City of Albuquerque

November 2, 1992

RE: RE: DRAINAGE PLAN FOR PRESBYTERIAN RADIATION THERAPY (J19-D57)
ENGINEER'S STAMP DATED 10/26/92.

**PRESBYTERIAN RADIATION THERAPY
GRADING & DRAINAGE PLAN**

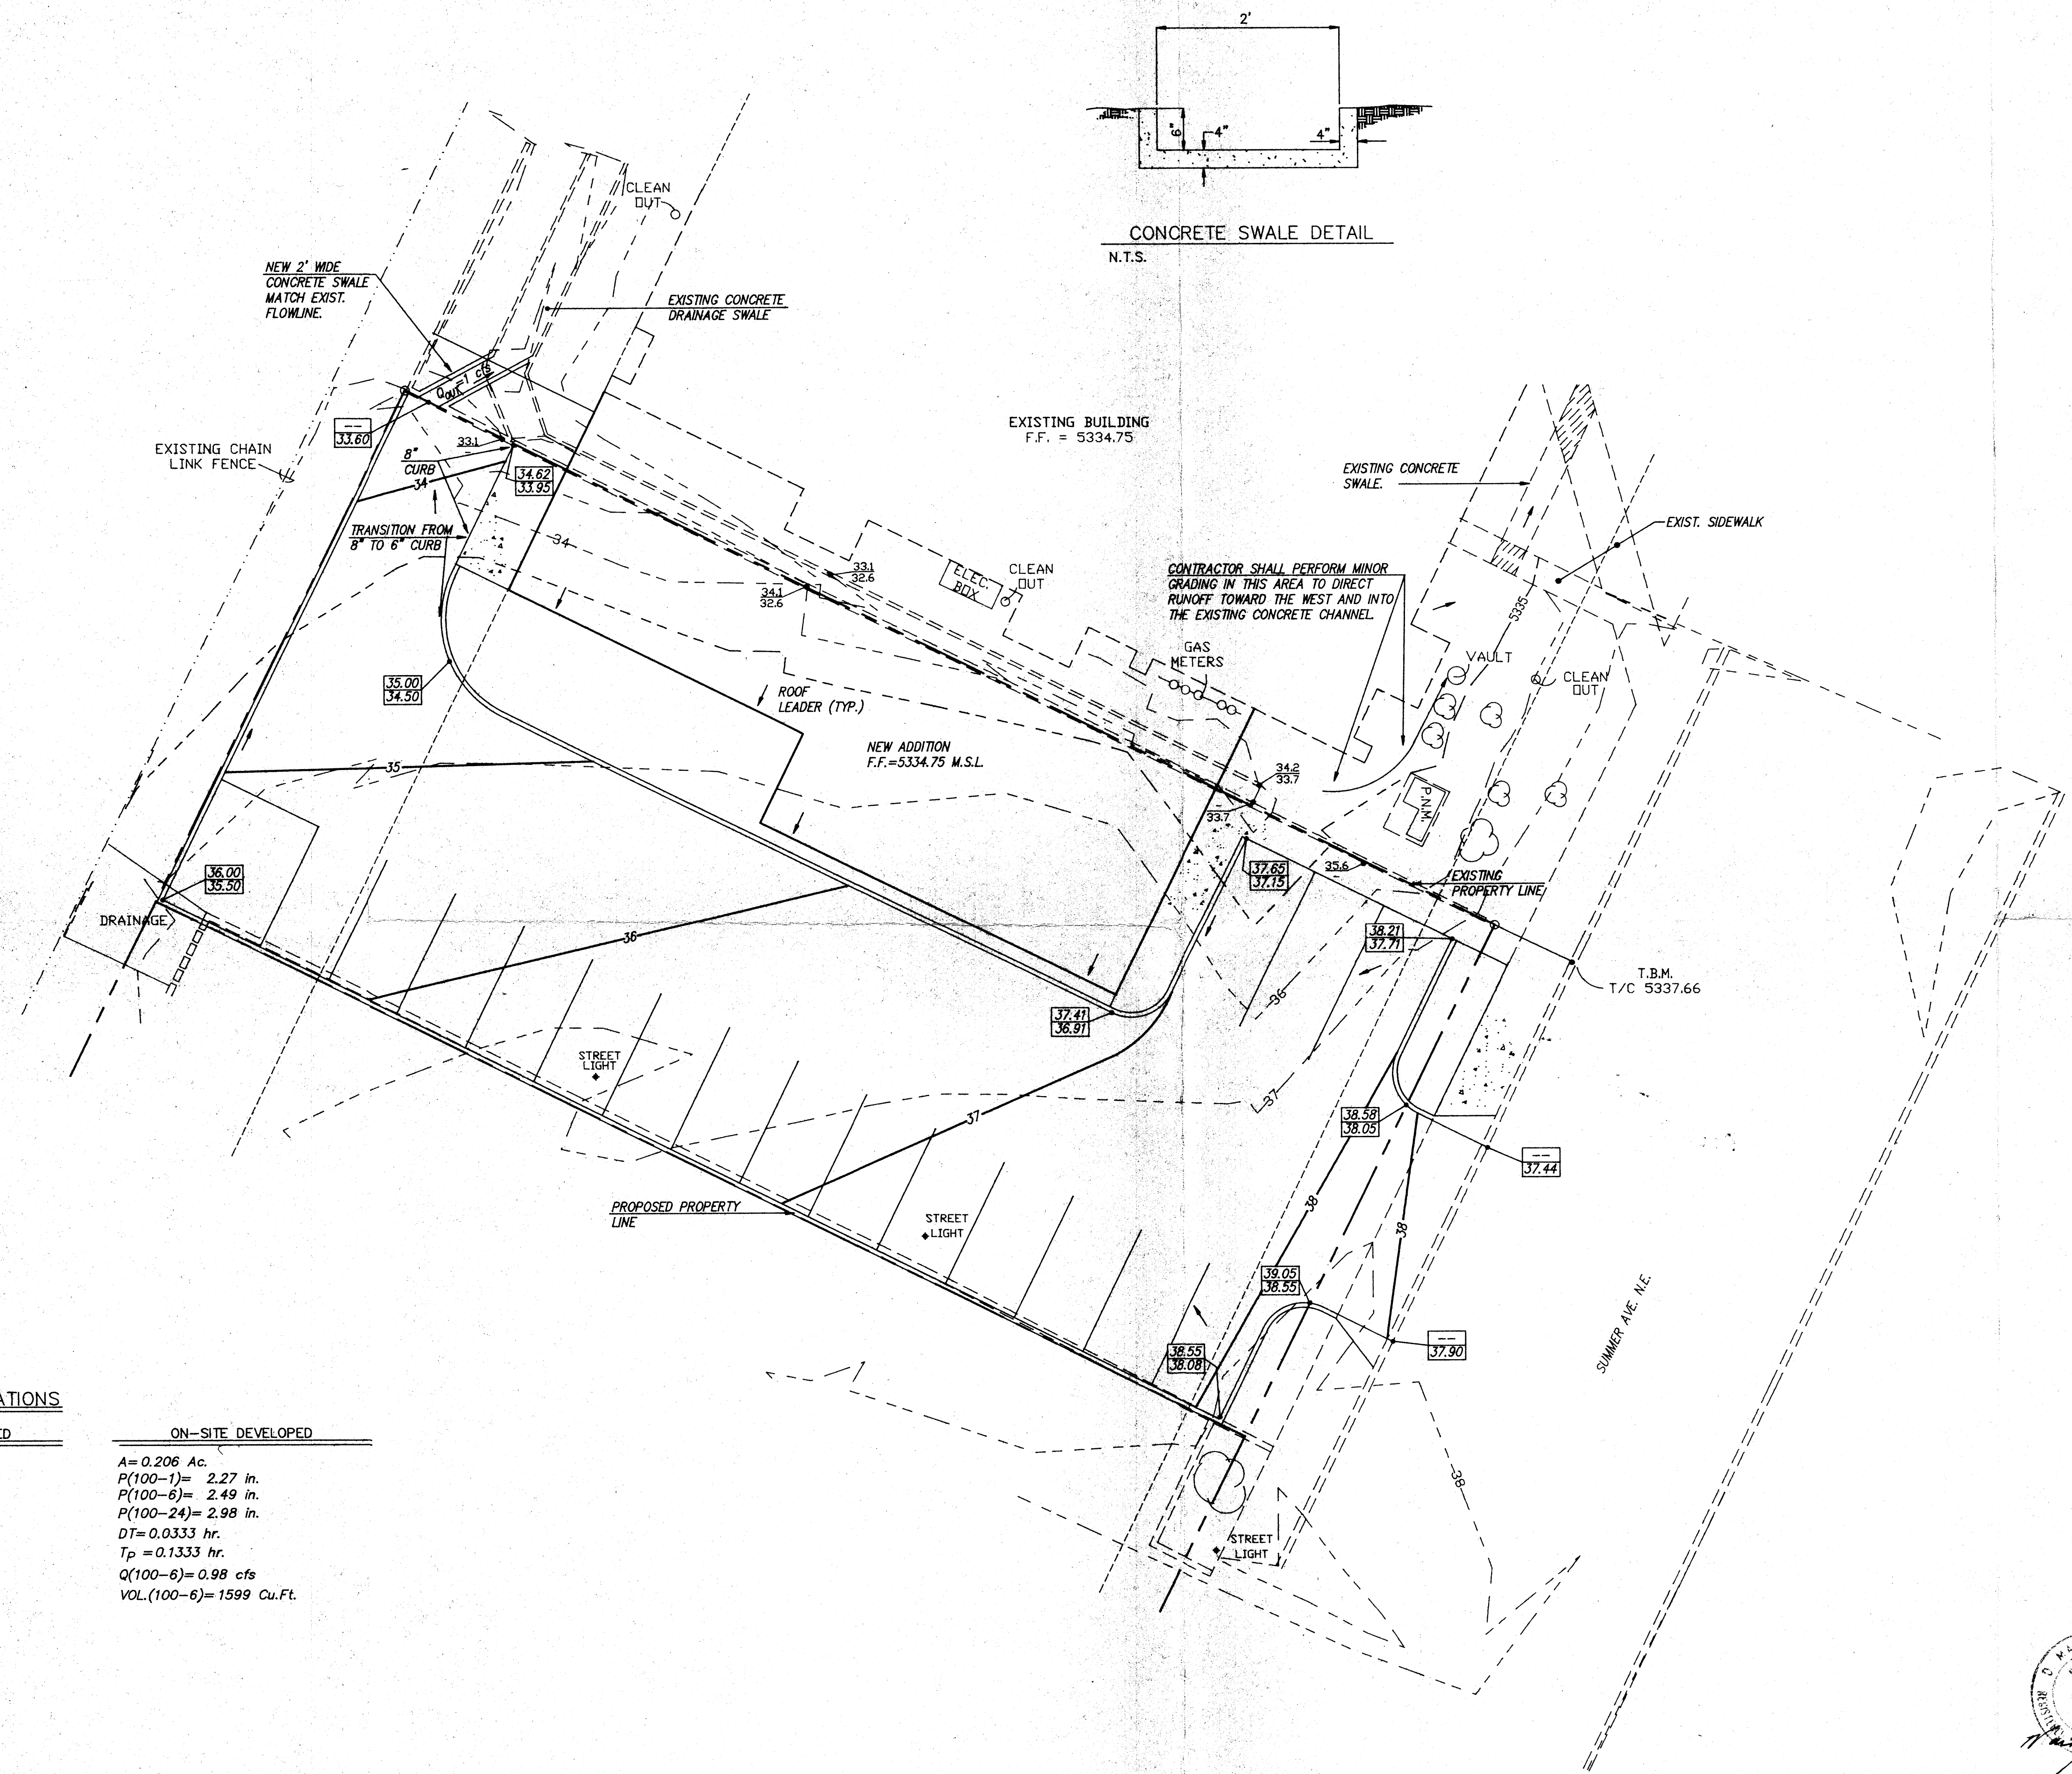
Please attach a copy of this approved plan to the construction sets prior to sign-off by Hydrology. Also, please be advised that any roof run-off entering a landscaped area will need to be provided with a curb cut to access water onto the paved area.
